Recommendation Report for Planning Permission for Works or Extension to a Dwelling

REF NO: AW/354/21/HH

LOCATION: 4 Alexander Close
Aldwick
PO21 4XQ

PROPOSAL: Single storey front extension as part of conversion of garage.

sheet 1 of 3

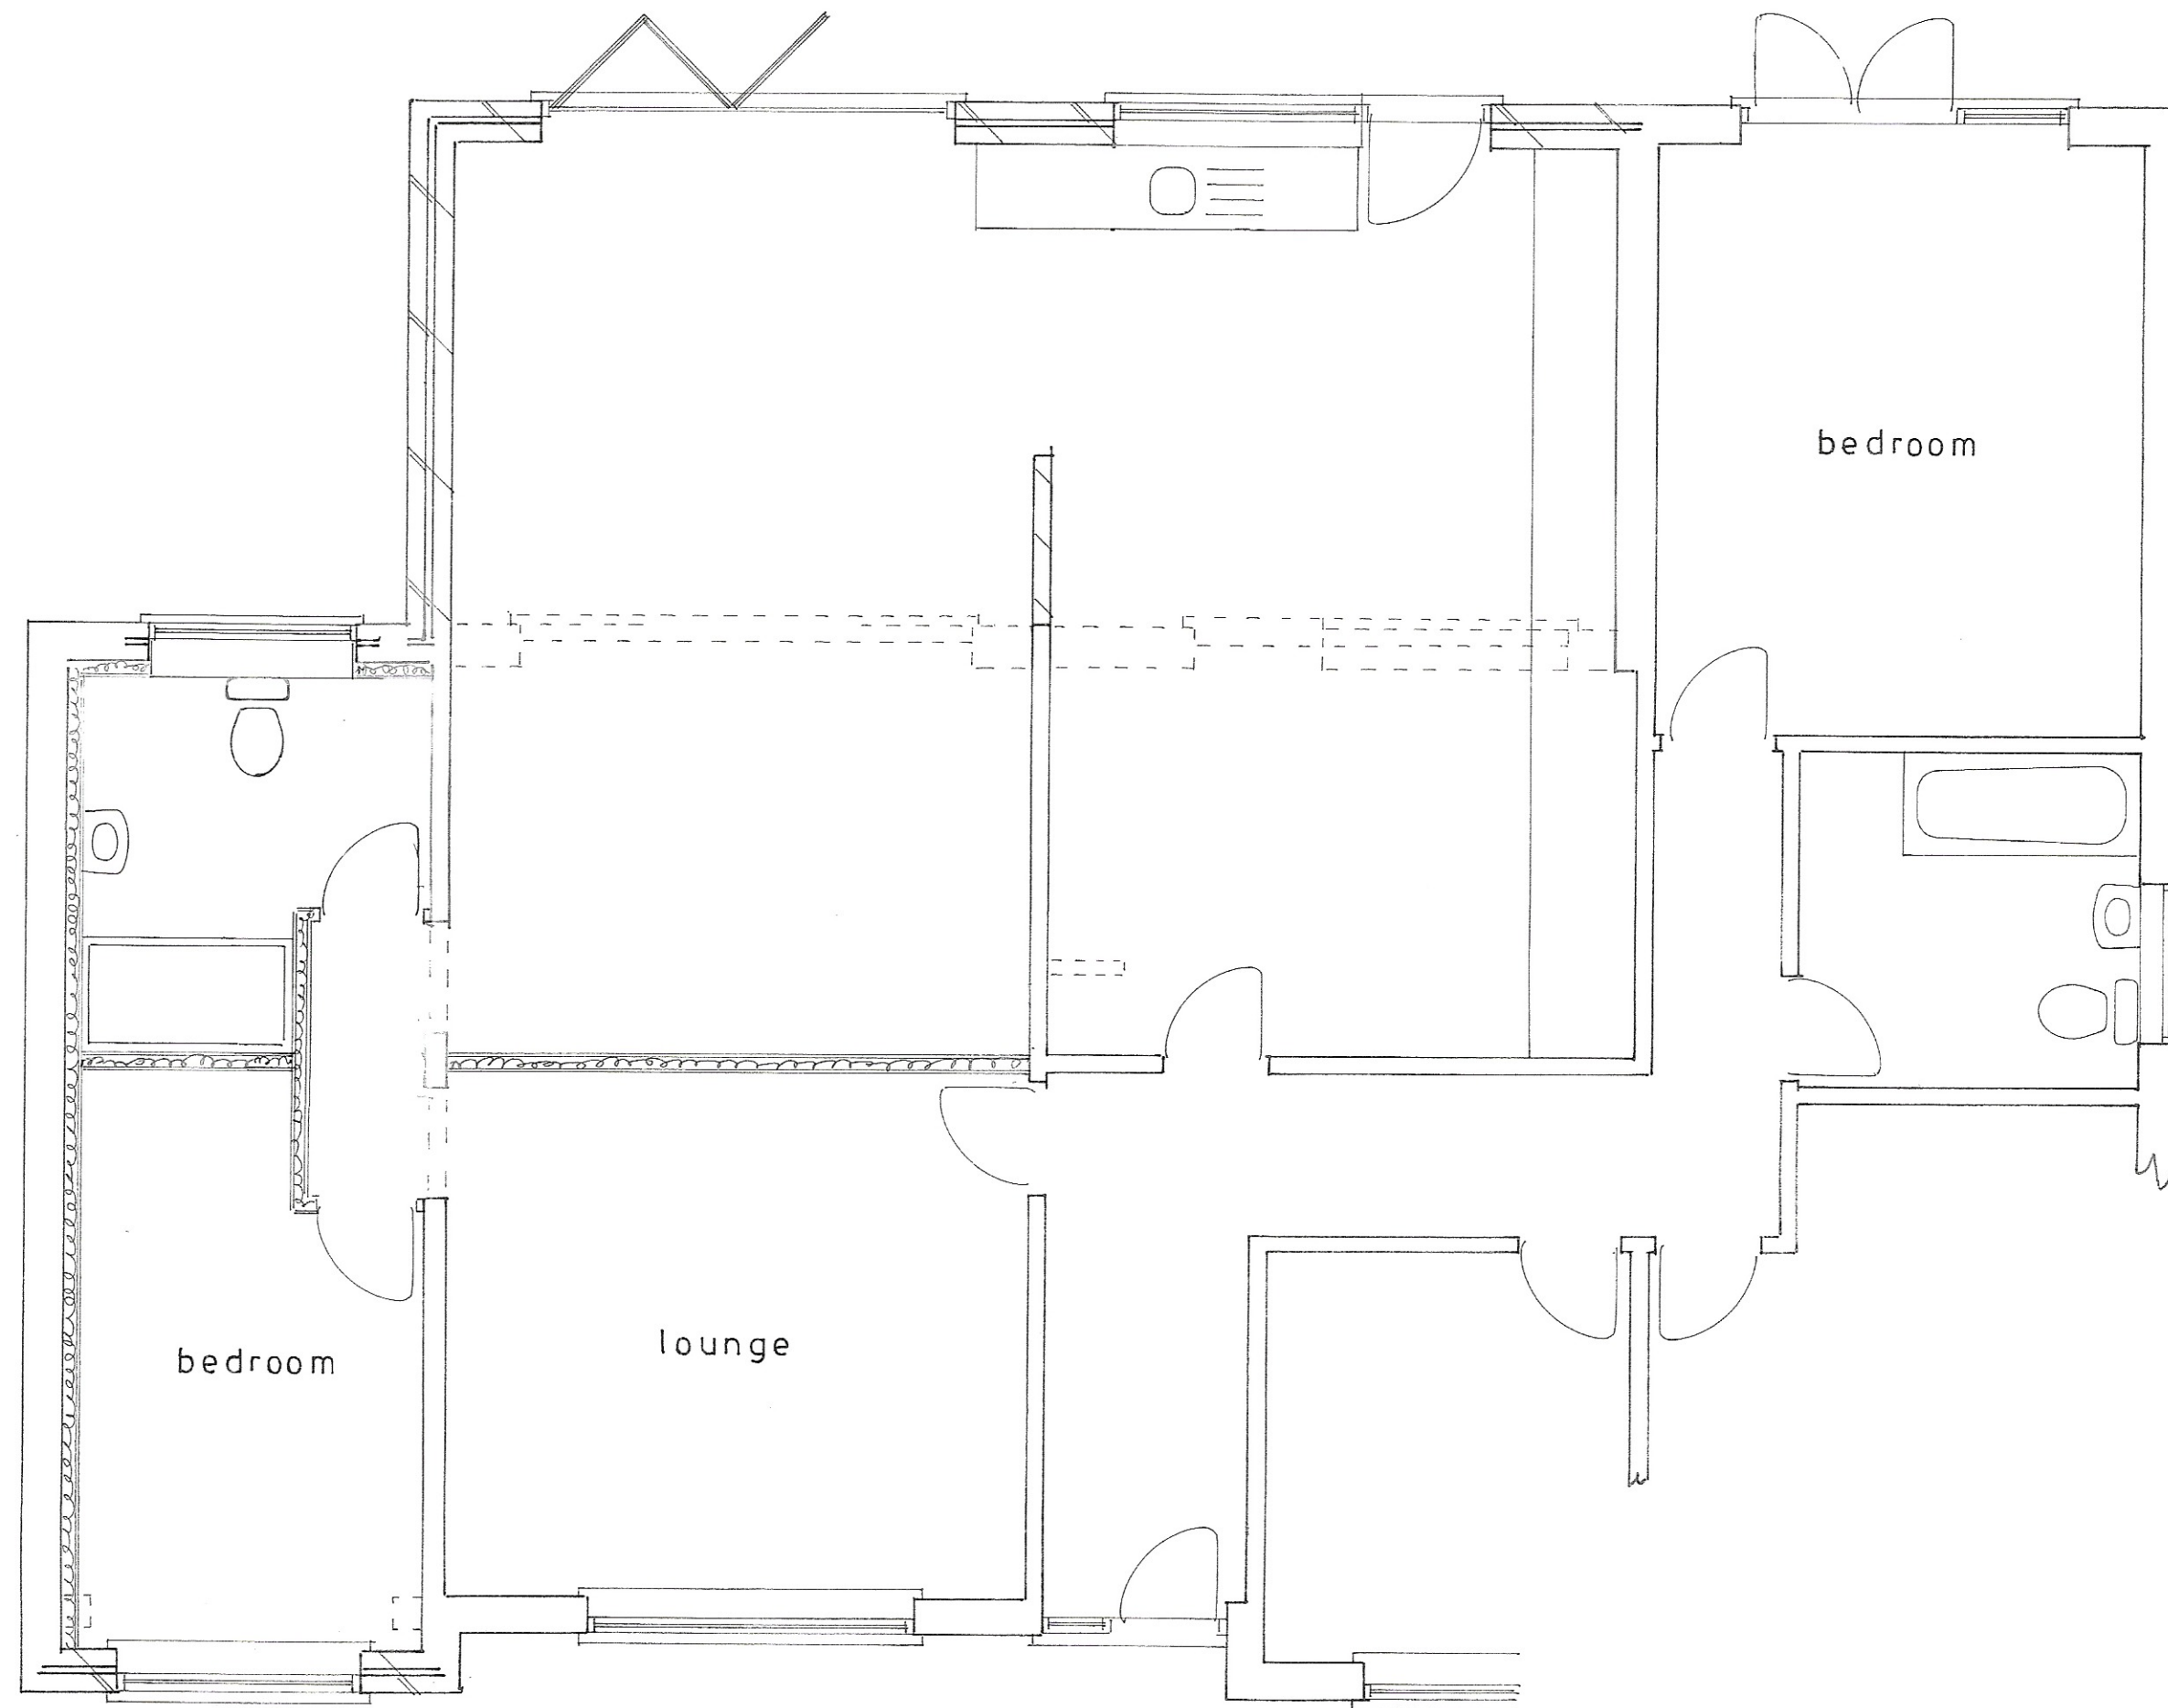
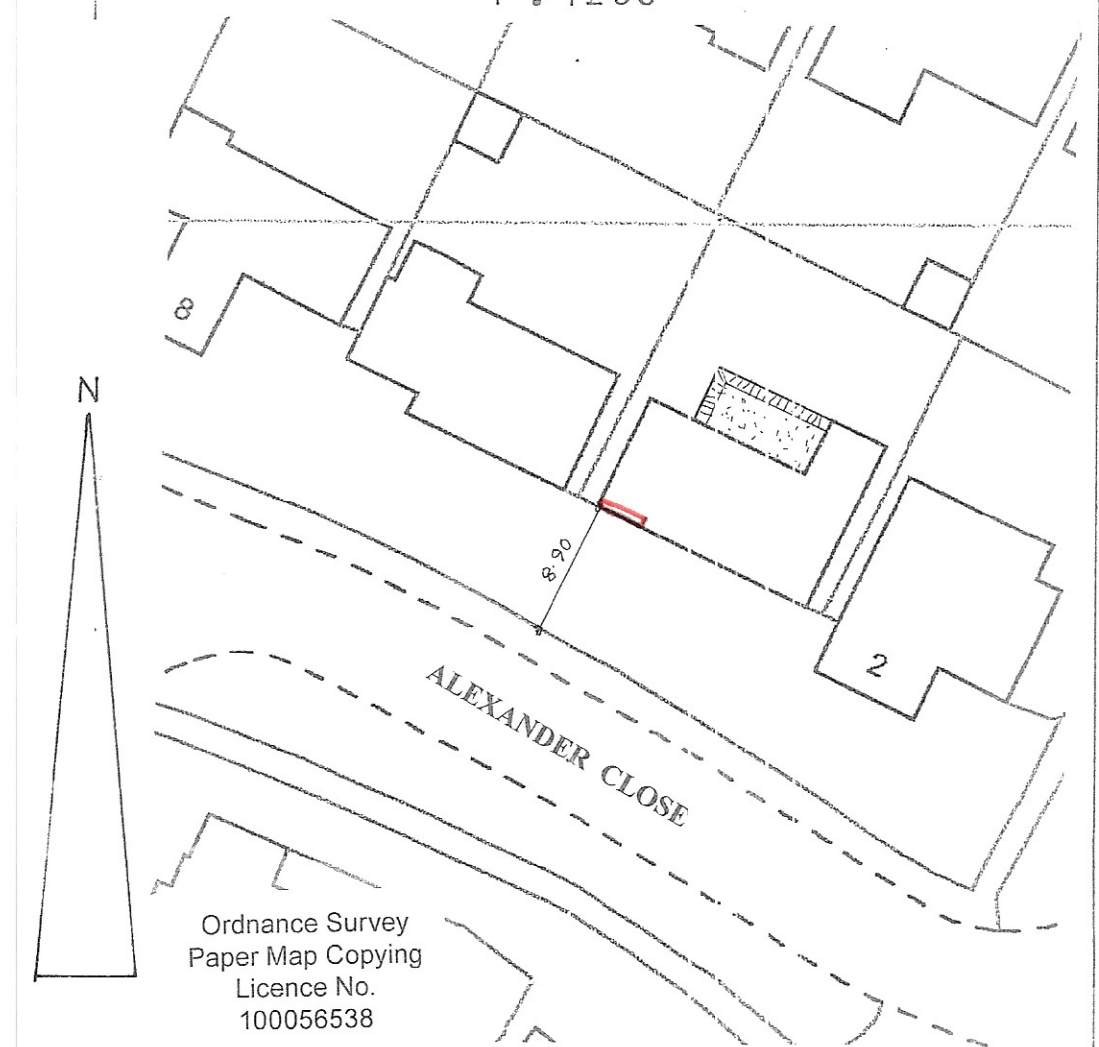
The proposed single storey front extension will convert existing attached garage to west into a new bedroom and bathroom. It will retain same width and depth as existing garage. It will project forwards (south) within the same building line as existing garage so it will be in line with front principal elevation.

Arun recently adopted a Design Guide. It states development should be subservient to the main dwelling and this complies in terms of size and scale. It states that front extensions should generally be no deeper than 1.5 metres and should not be the full width of the building. The proposal complies with this.

It states that rear extensions can however impact neighbouring amenity. The proposal seems to pass the 45 degrees test to ascertain whether it will affect light levels from the ground floor windows of the neighbouring property so is acceptable.

The proposed conversion of garage to habitable accommodation will have minimal impact on neighbouring amenity due to no additional increase in height, length or width over existing garage.

Due to proposed new rear extension there is no adverse harm to overbearing or overshadowing effects to neighbouring property no. 6 to west due to a gap of around 4.05m retained to the boundary, a large gap to the neighbouring property and being at single storey there is no adverse harm caused.

sheet 2 of 3

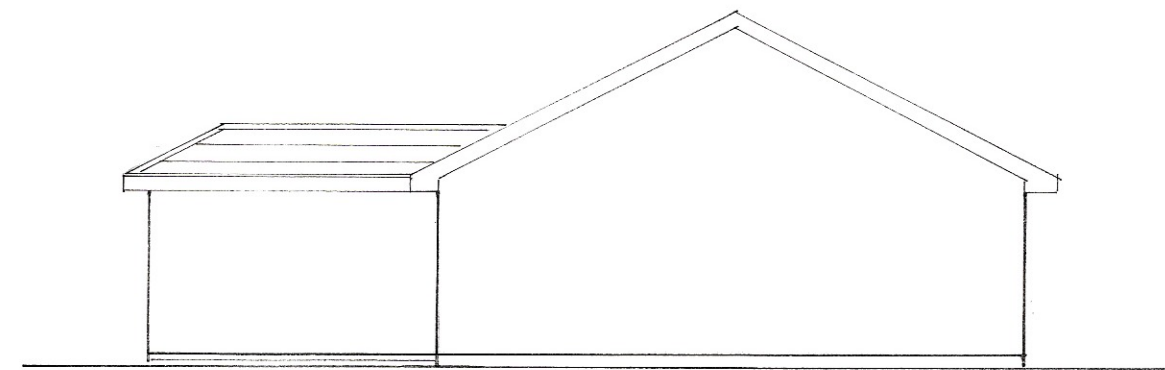
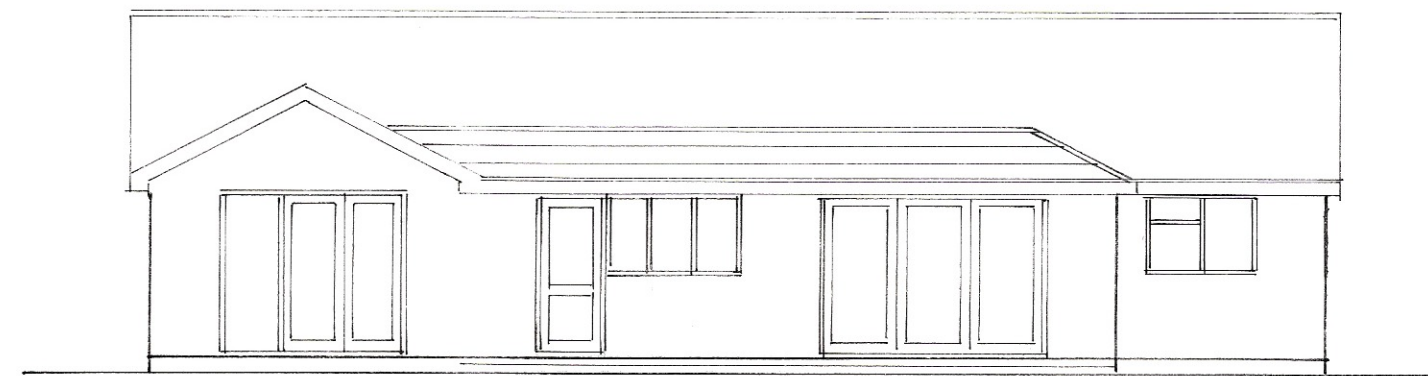
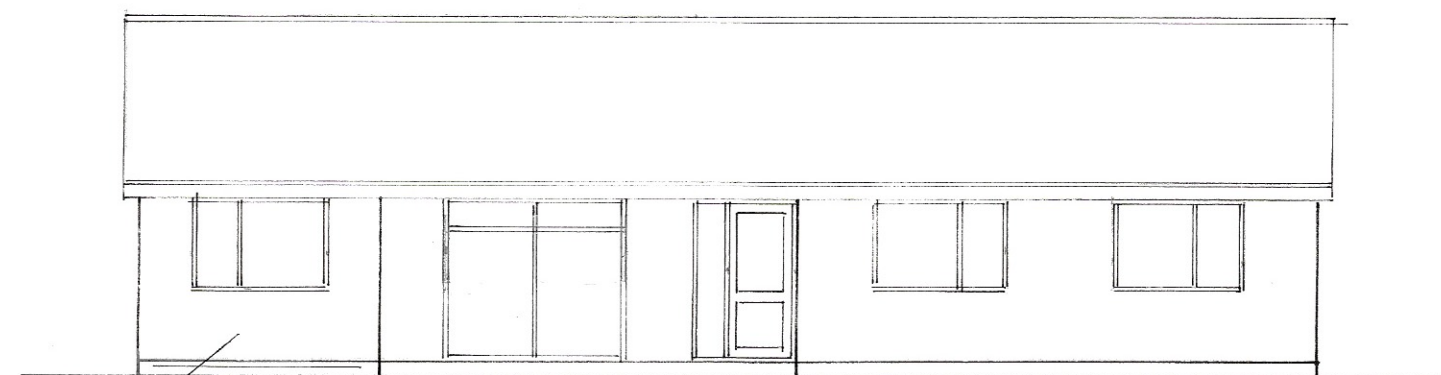
Due to siting to front (south) the changes are highly visible from the street scene however due to no additional height and minimal increase in length projected forwards there is no adverse impact on street scene or character of area so complies with policy D DM1 of the Arun Local Plan and Aldwick Design Statement.

There will be one new large window (2 window panes) to front (south) and one new window (2 window panes) to rear (north) elevation.

The proposal will have a width of approximately 8.80m and a depth of approximately 3.80m. The height to pitched roof will be approximately 3.27m. There is around 8.74m to the north and 4.22m retained to the west boundaries. There will be new sliding doors (3 panes), one new window (3 window panes) and one new single door to rear (north) elevation.

The proposed materials seem to match existing dwelling and consist of facing brickwork to walls to

match, UPVC windows and doors so complies with policy D DM1 and D DM4 of the Arun Local Plan and the Aldwick Design Statement.

Due to the new window to front (south), a gap of around 8.90m retained to front boundary and location of road to front there is no harm to overlooking to neighbouring amenity to south so is acceptable.

Due to the one new window to rear (north), being at single storey and existing boundary fence to rear there is no harm to overlooking to north or west.

Due to the new sliding doors, new window and single door to rear (north) there is no adverse harm to overlooking to neighbouring amenity to north due to a large gap of around 8.74m retained to the rear boundary and properties set back by gardens so is acceptable.
